Norwich to Tilbury

**Document: 9.1 Notification of proposed change to DCO application -
Change Request 1 (Bulphan)**

Application by National Grid Electricity Transmission (the Applicant) for an Order Granting Development Consent for the Norwich to Tilbury Project (Planning Inspectorate Reference EN020027)

Bulphan: Change to Third Party Access and Works (Change Request 1)

THE NATIONAL GRID (NORWICH TO TILBURY) ORDER
 PROPOSED CHANGE ORDER LIMIT PLANS - CHANGE REQUEST 1
 PROPOSED CHANGE TO THE PROJECT ORDER LIMITS
 REGULATION 5(2)(o)
 SECTION H (SHEET B, THURROCK COUNCIL)

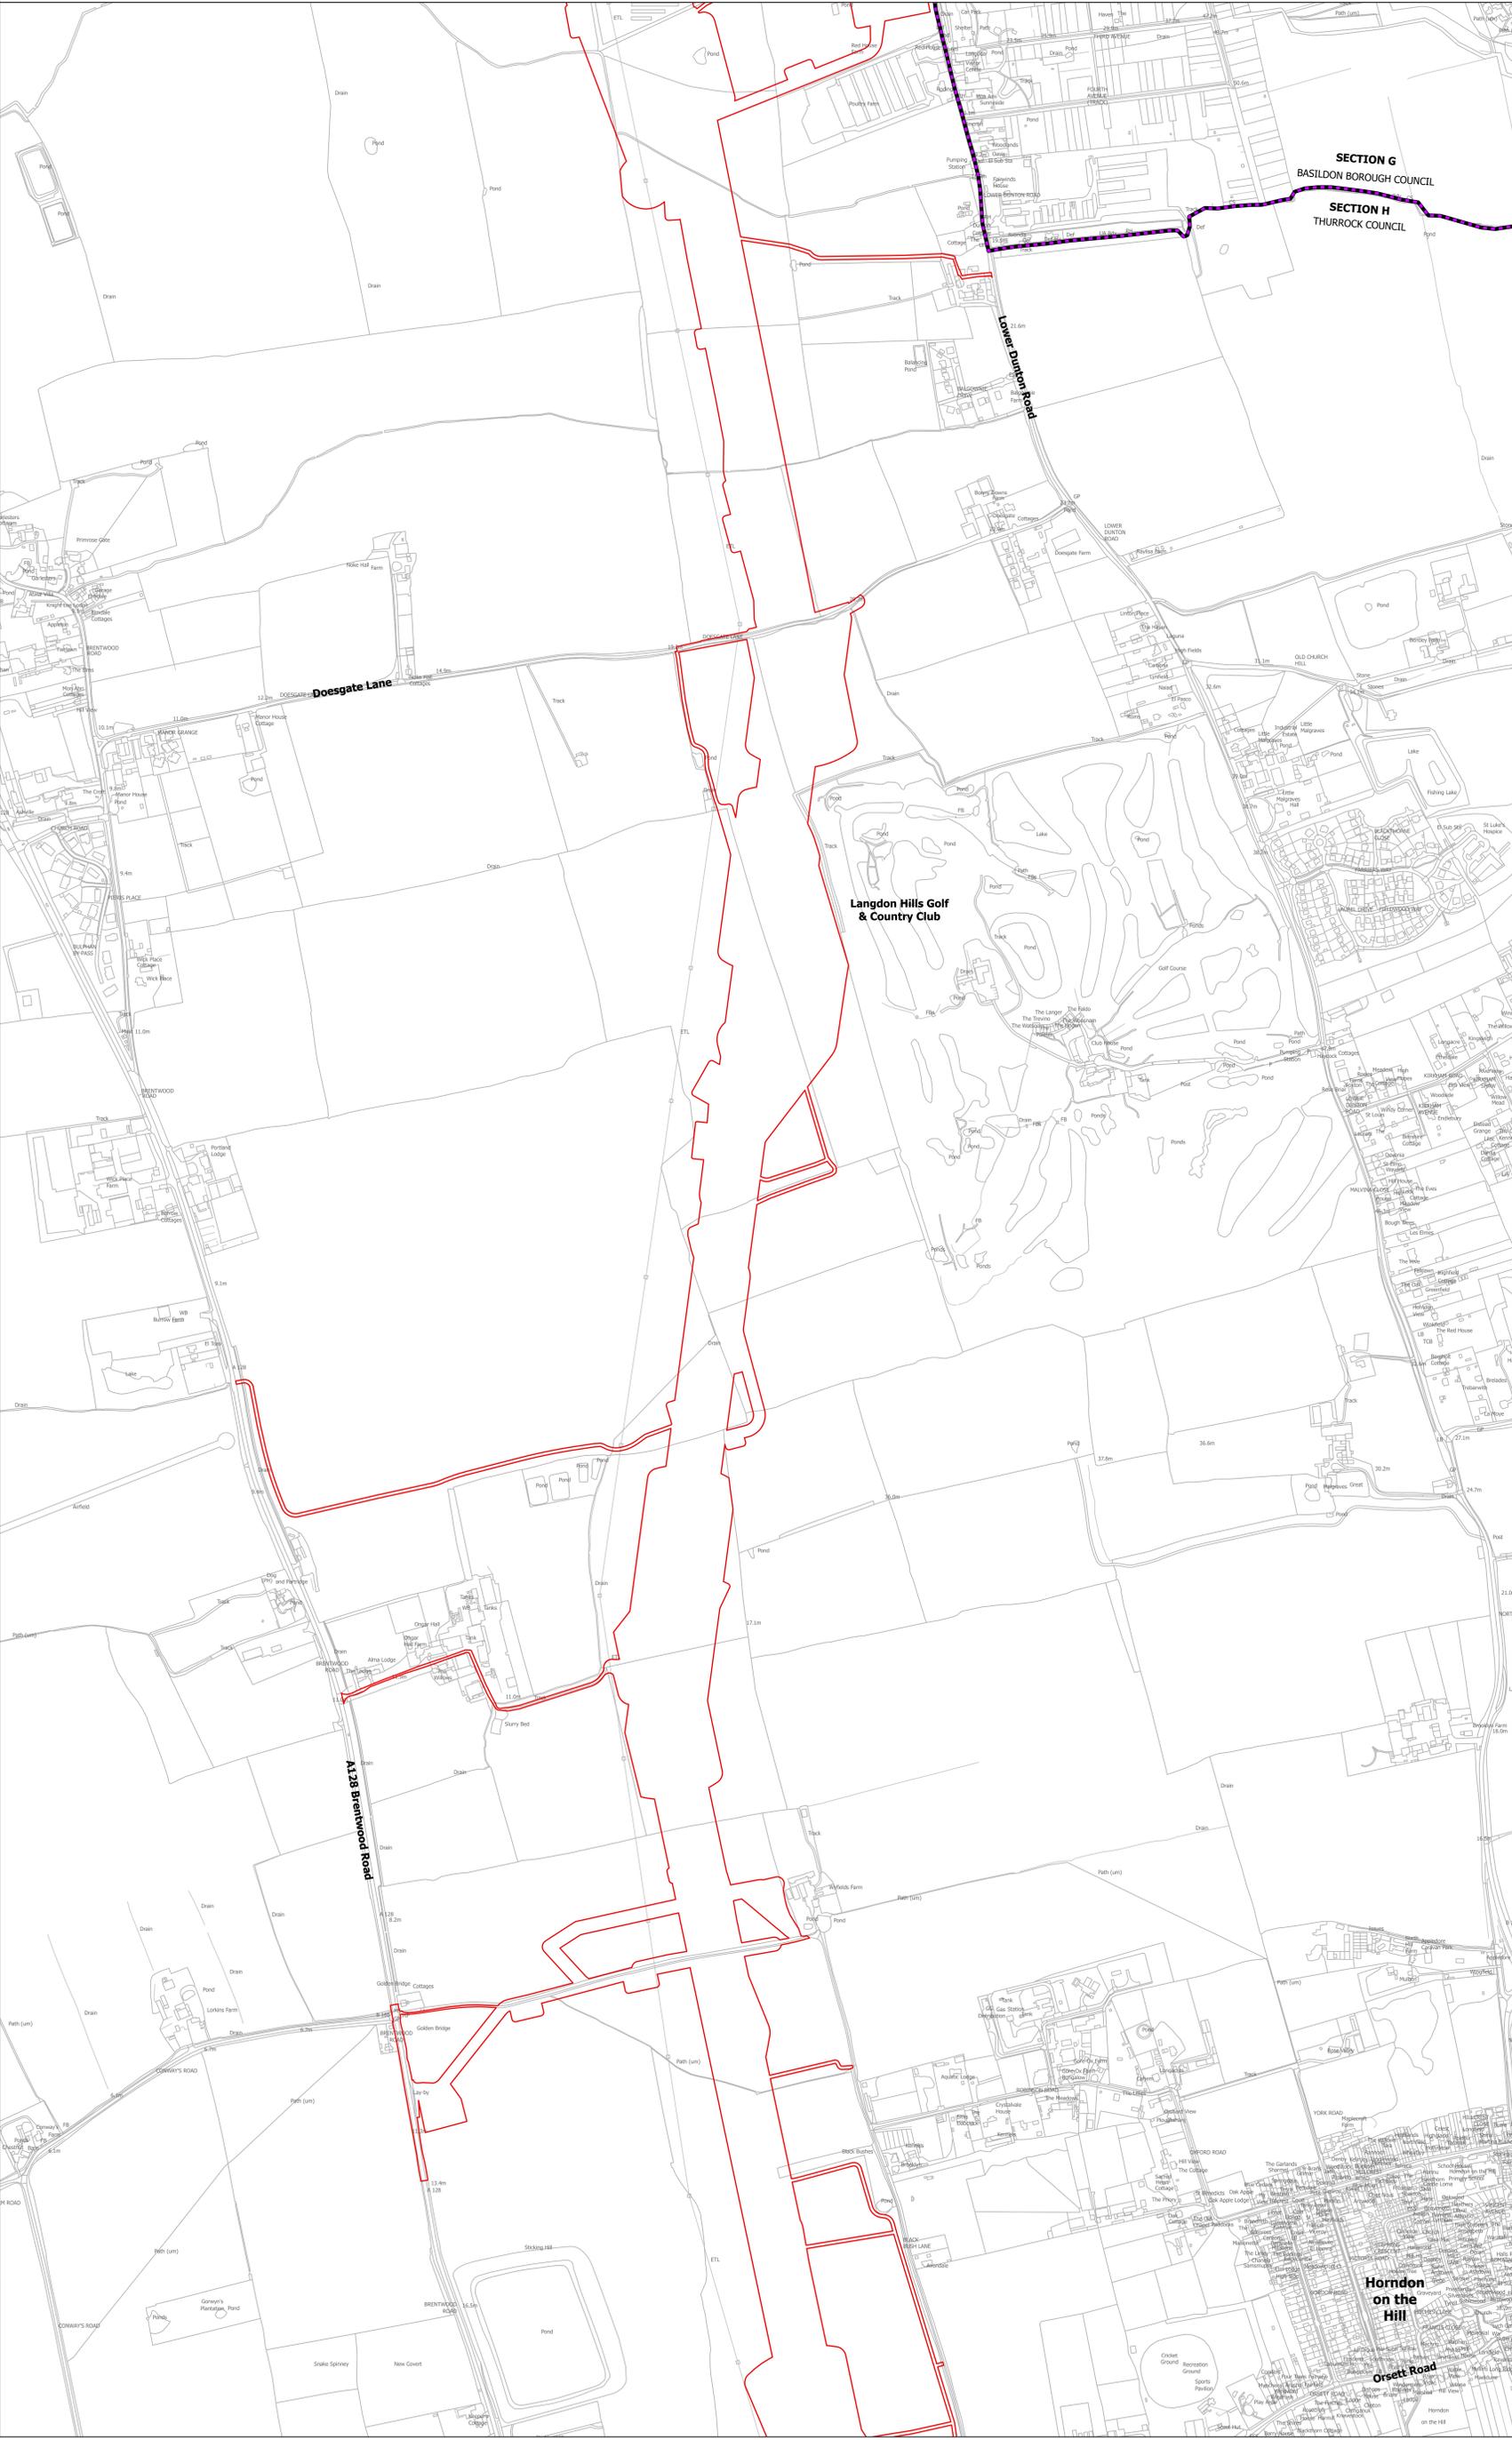
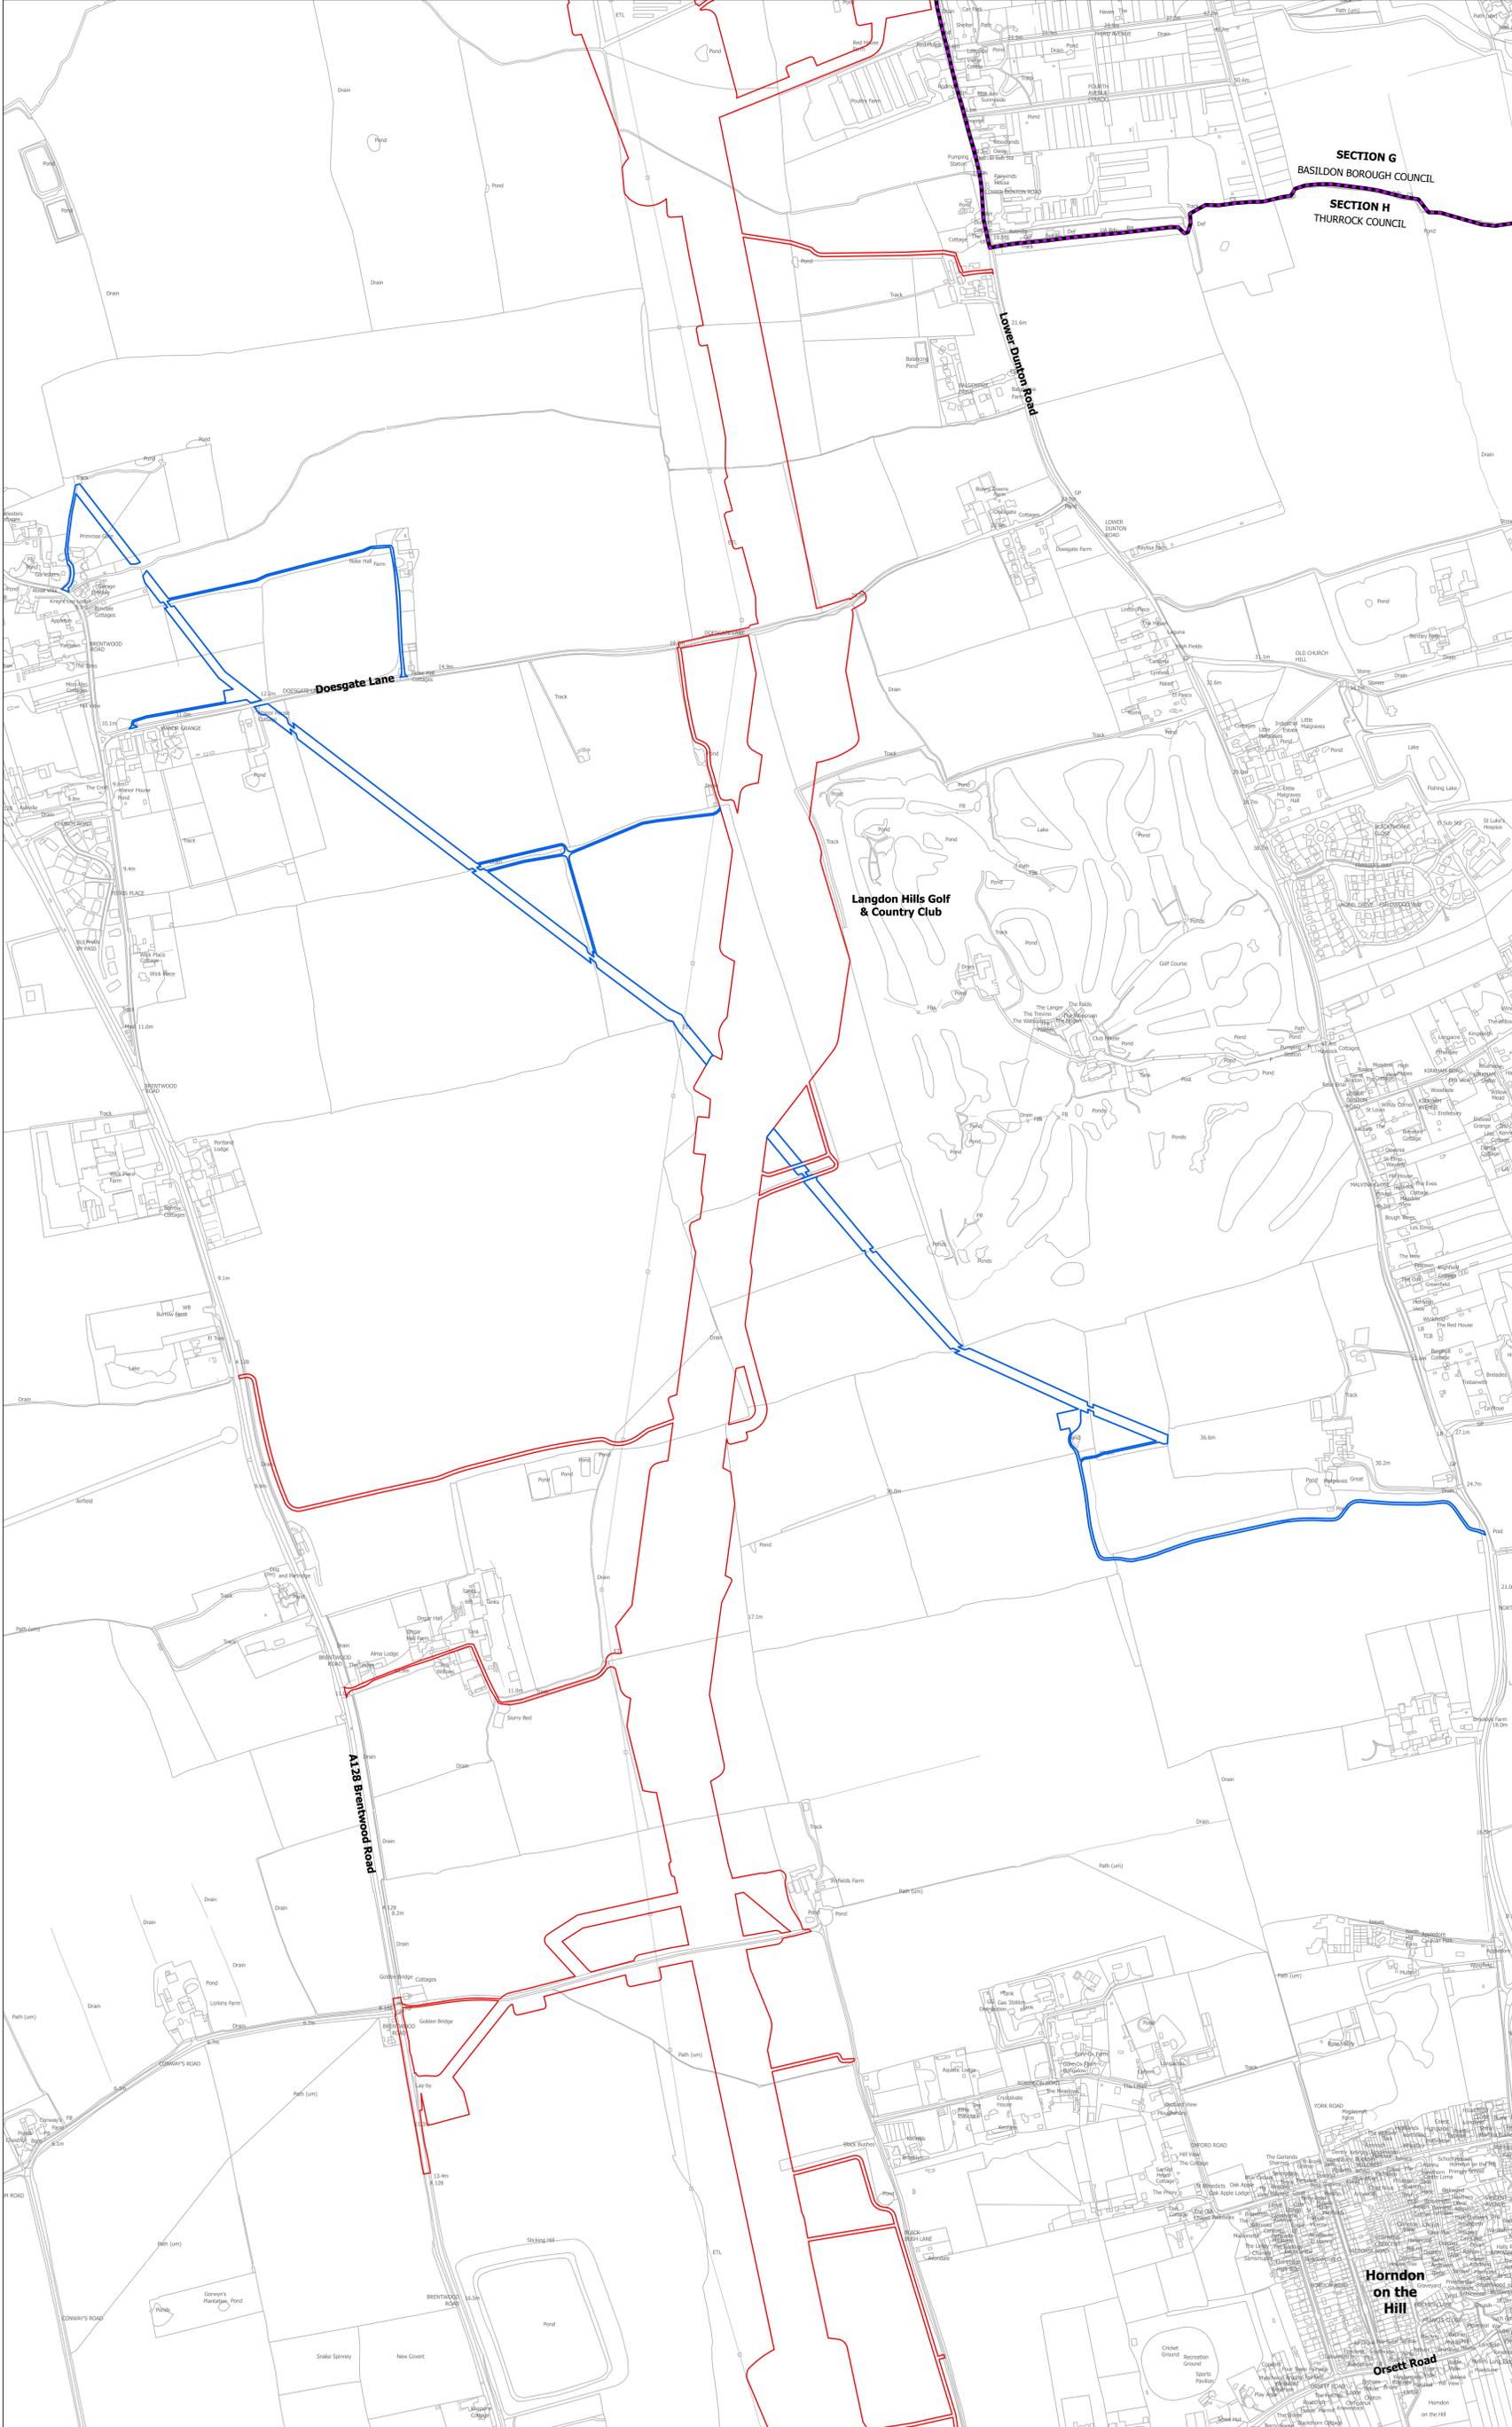
Change request number	Name of proposed change and description
1	Bulphan: Changes to third party access and works (Section H): an increase in the Order Limits to facilitate works required for the protection of the existing Thames to Buncefield Multifuel Pipeline, west of Langdon Hills Golf Club. This proposed change responds to feedback concerning accelerated corrosion on existing buried metallic services received from the British Pipeline Agency Ltd (BPA) who act as the agent for the owner, United Kingdom Oil Pipelines Limited (UKOP).

- 2.1.5 The proposed alignment for the Project (between Pylon TB239 and TB240) (see Section H of **Works Plans (APP-024)**) will cross the Thames to Buncefield Multifuel Pipeline to the west of Langdon Hills Golf Club. The pipeline, which forms part of the national fuel infrastructure network, is operated by the British Pipeline Agency Ltd (BPA) who act as agent for the owner United Kingdom Oil Pipelines Limited (UKOP).

- 2.1.6 As part of ongoing technical and survey work to inform detailed design, the Applicant has undertaken pipeline studies. The work identified the need for mitigation works to be carried out in respect of the existing Thames to Buncefield Multifuel Pipeline. The proposed measures are likely to involve the installation of zinc earthing strips parallel to, and along, an approximately 2.7km length of the existing pipeline, along with the installation of surface mounted monitoring equipment units. Temporary working and laydown areas will also be required.

- 2.1.10 The Order Limits are to be increased as a consequence of the proposed change, with powers of compulsory acquisition and temporary possession to be sought by the Applicant over the additional land intended to be brought within the Order limits. Accordingly, the CA Regulations are engaged.

2.1.12 The proposed change to the Order Limits is shown on the figures in **Appendix A**.
